# CITY OF ALBUQUERQUE

February 6, 2012

**Re: Lowes Subdivision Lot 3  
Grading and Drainage Plan  
Engineer's Stamp dated 1-24-12 (A14/D006B)**

GRADING AND DRAINAGE PLAN

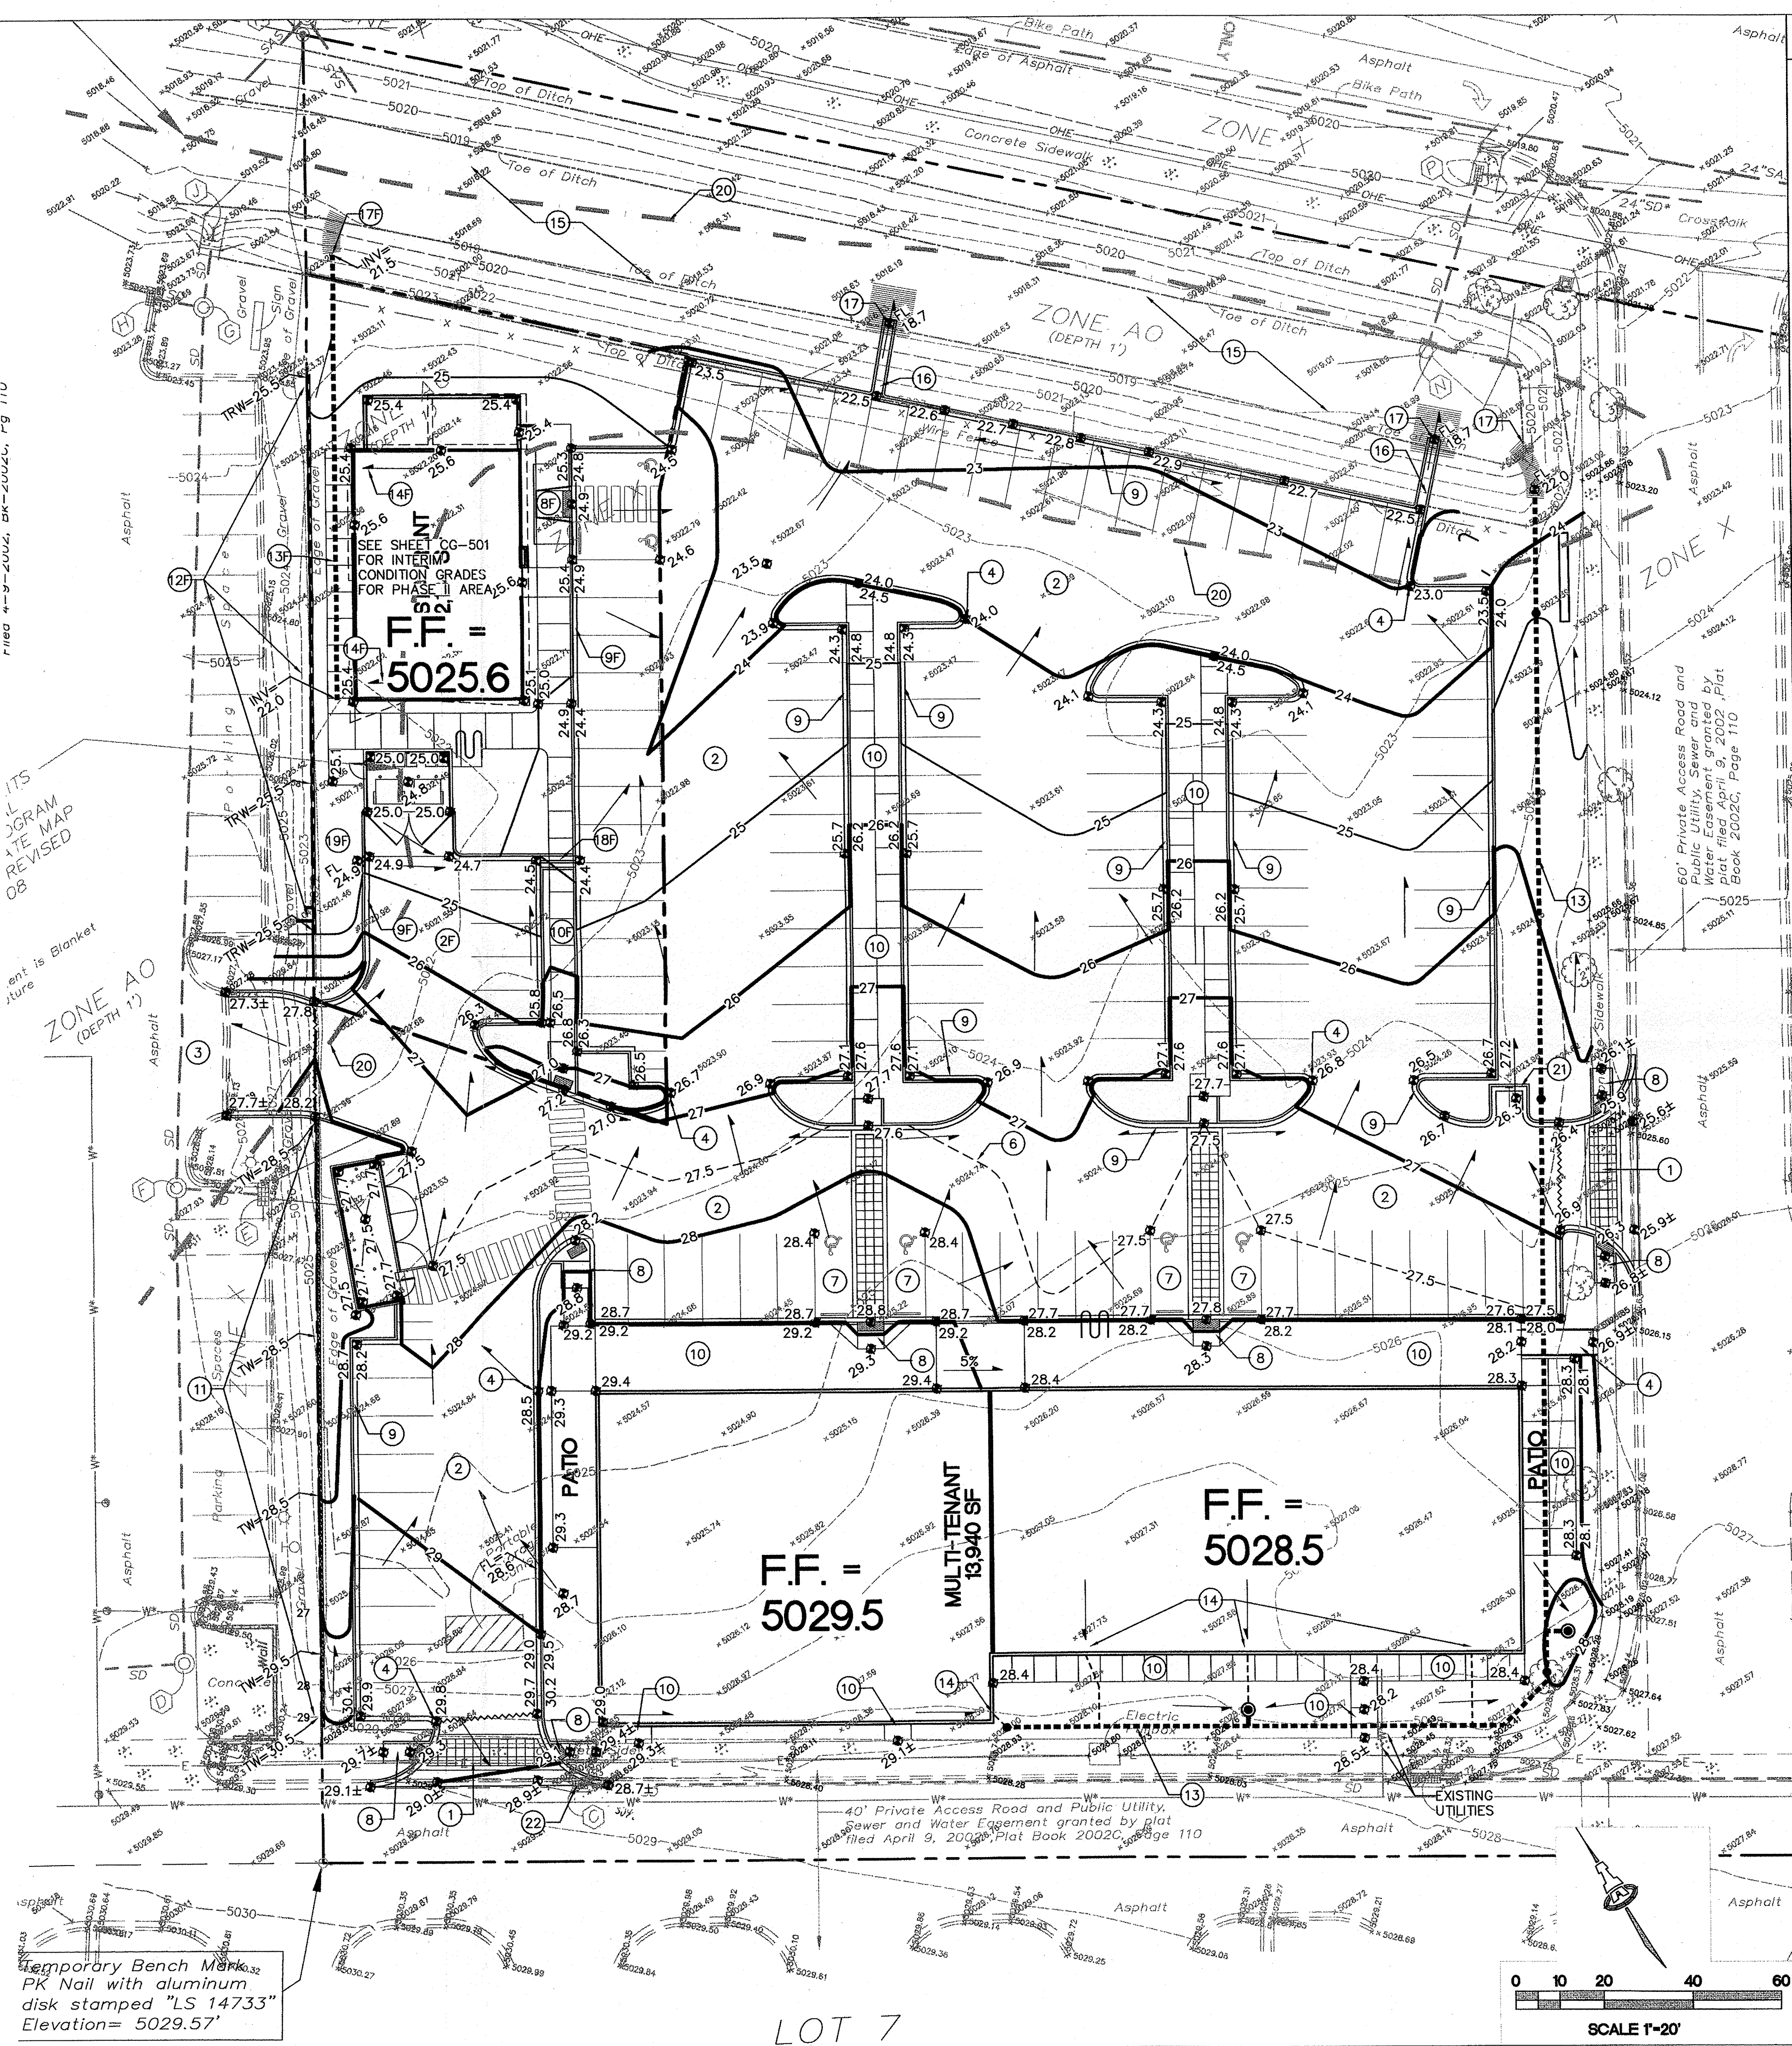
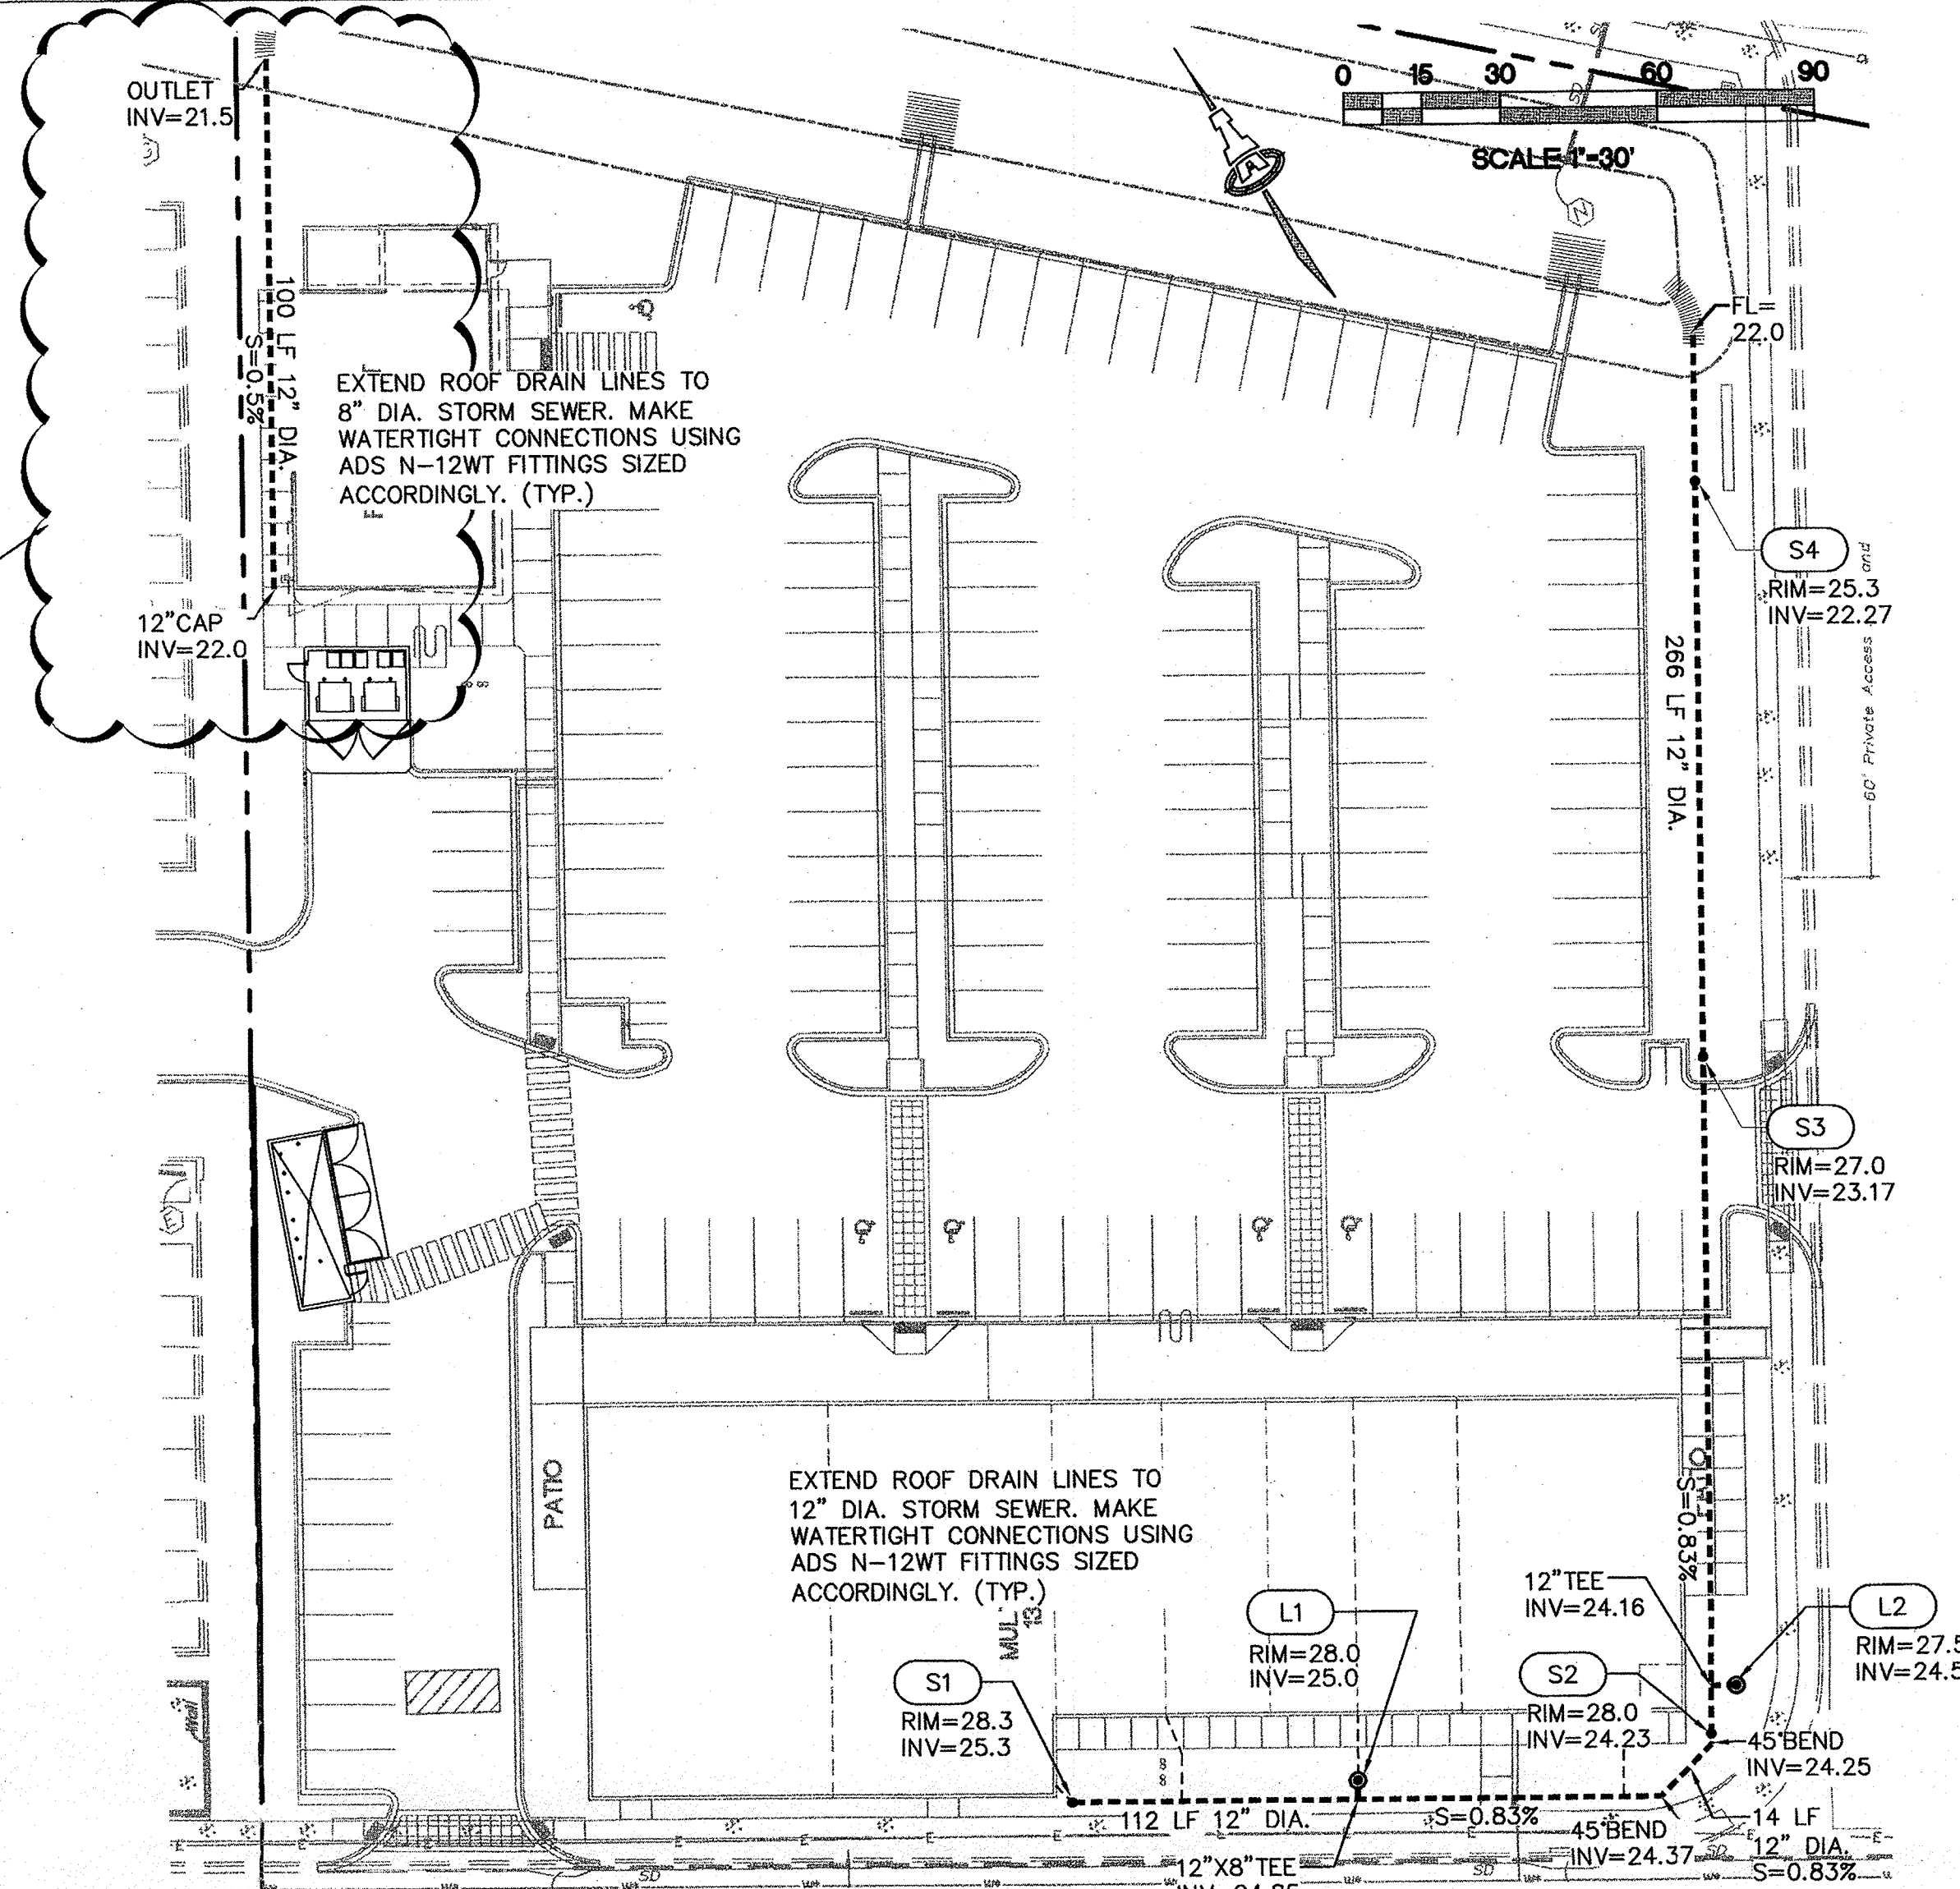
- Provide an analysis showing that the replacement of the "C" inlet with a "D" Inlet will not cause an unacceptable amount of bypass flow. Can the inlet be moved to the east?
- A floodplain permit is required for phase one.

Hydrology is requesting that all proposed landscape areas are depressed to retain/infiltrate the moisture that falls on them.
